***Adaptive Reuse of the Clare Hotel and
Administration Building on Block 3A***

***Central Park, Chippendale
(Former Carlton United Brewery)***

MP 11_0089 - Modification 1

Director-General's
Environmental Assessment Report
Section 75W of the
Environmental Planning and Assessment Act 1979

1 SECTION 06
 1:100

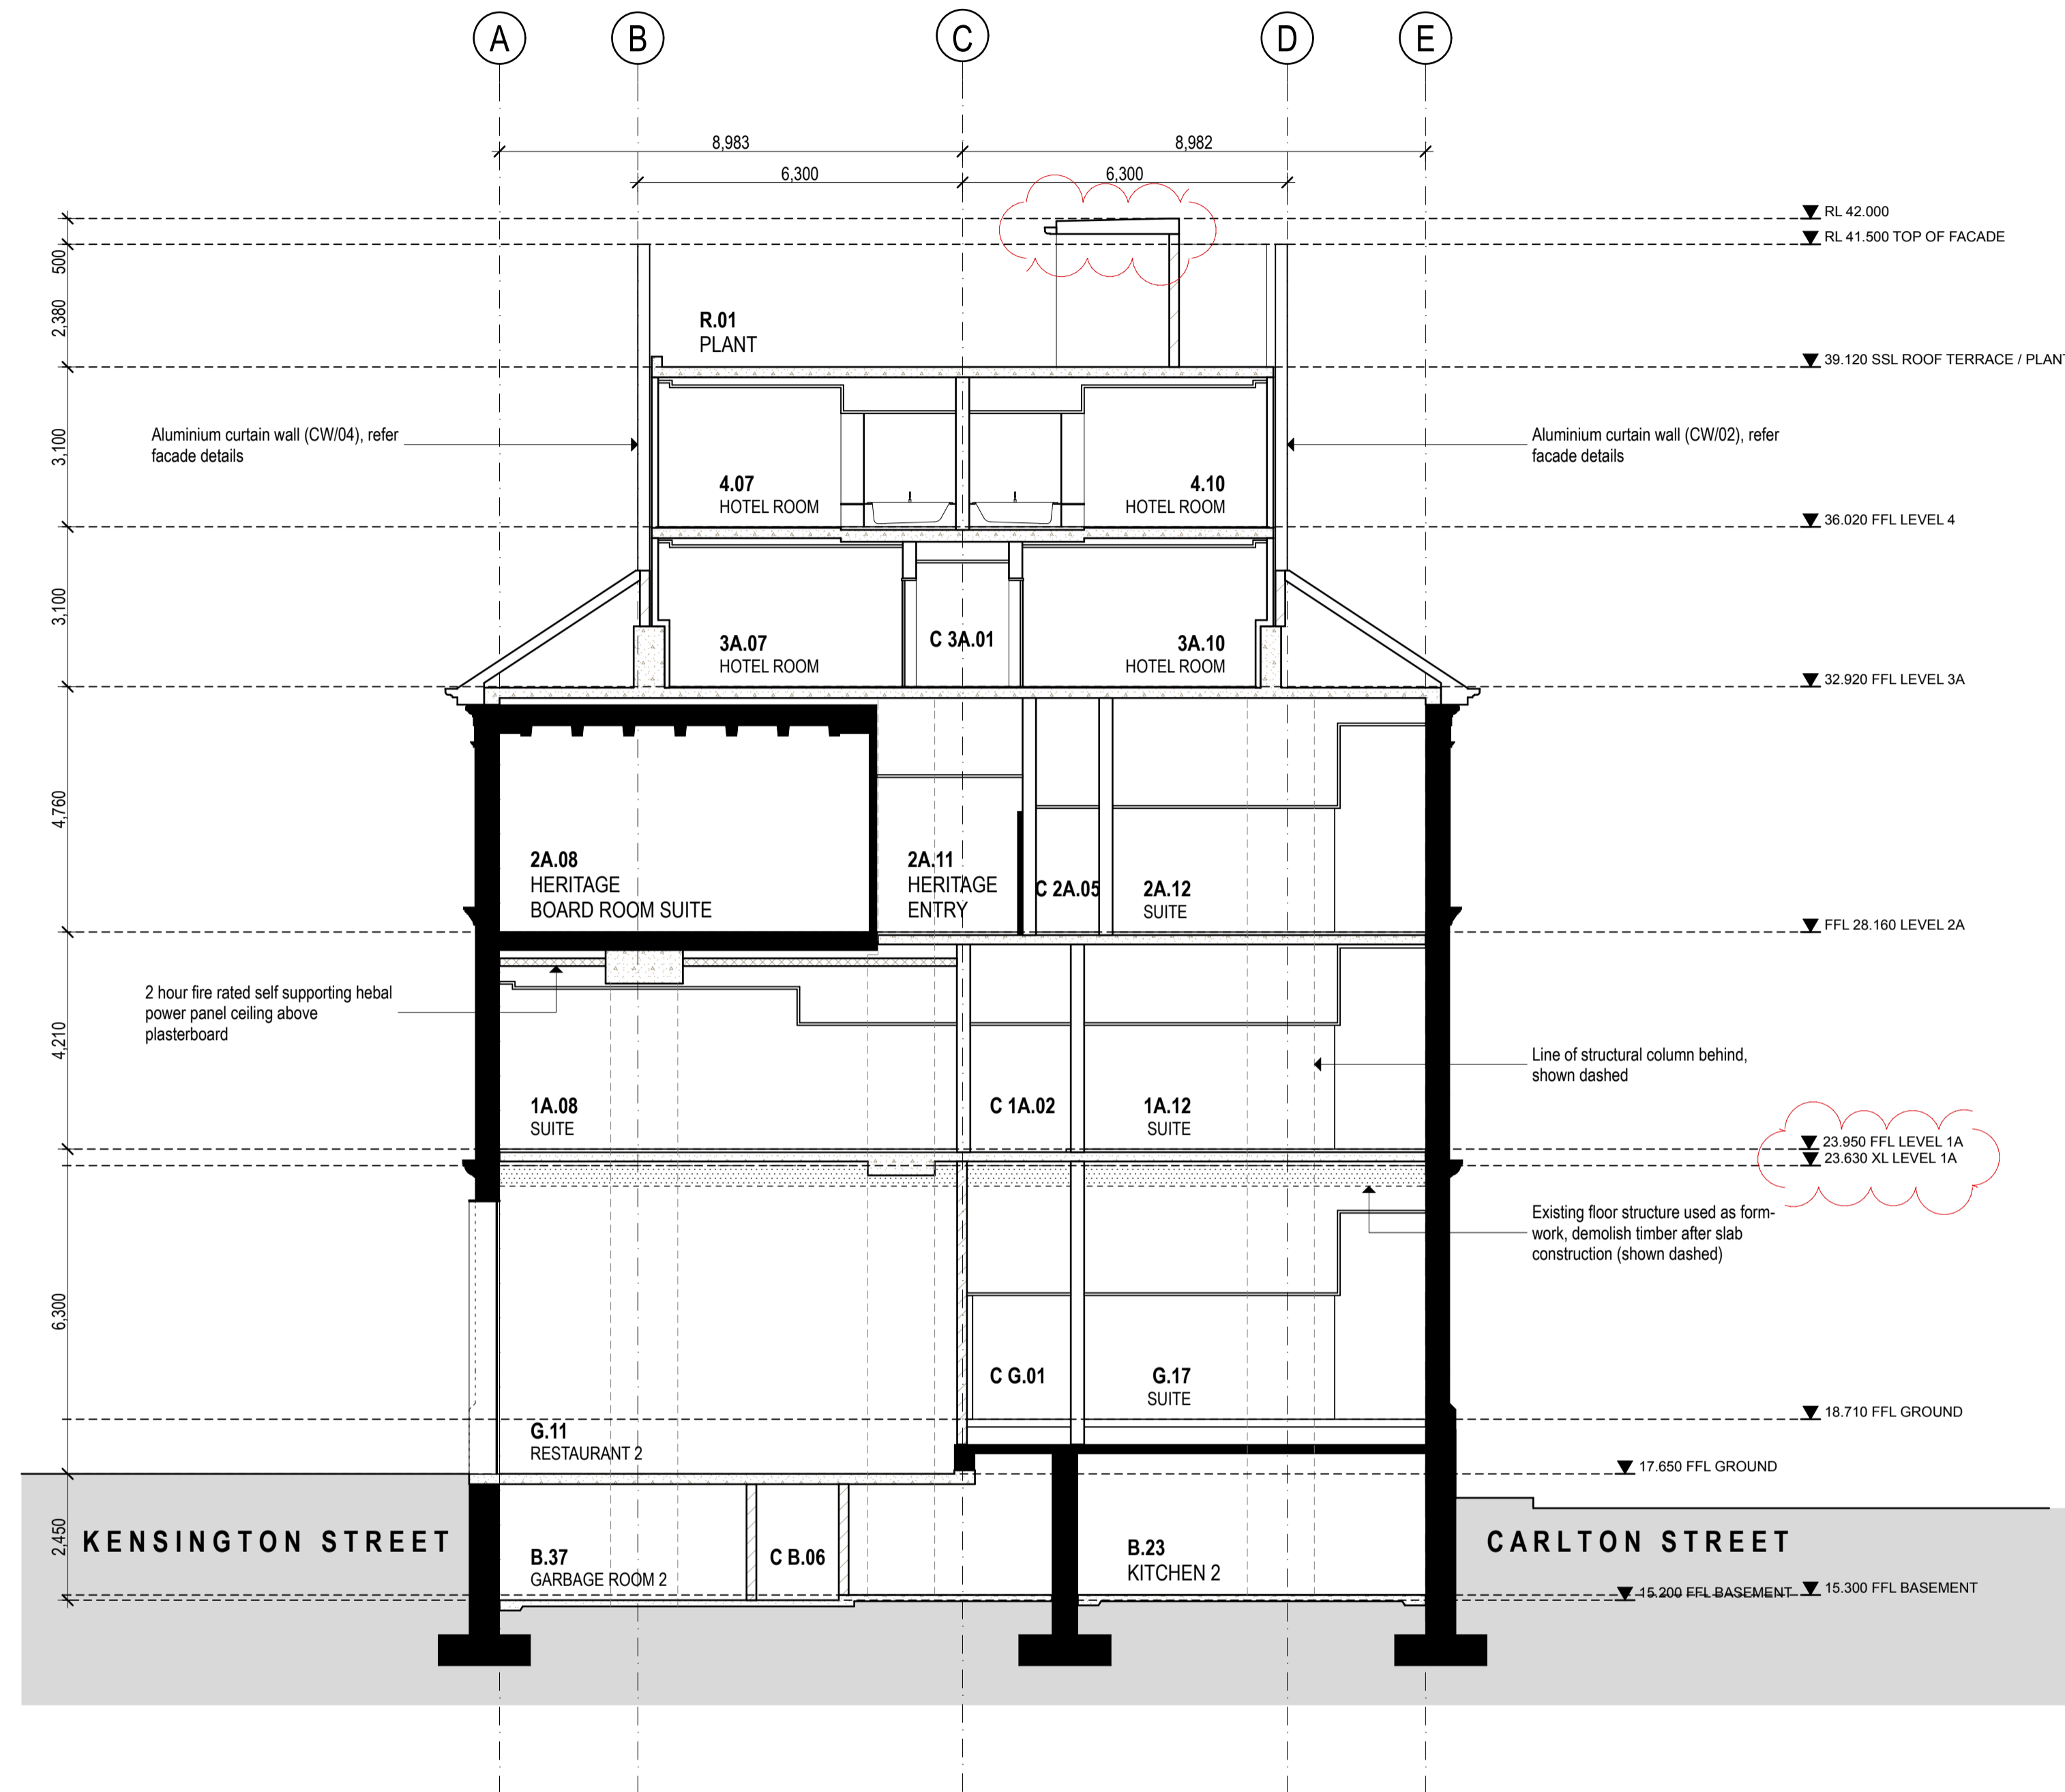
The proposed increase of 100mm to the pool deck roof canopies would change the maximum height of the development from RL 41.9 to RL 42.
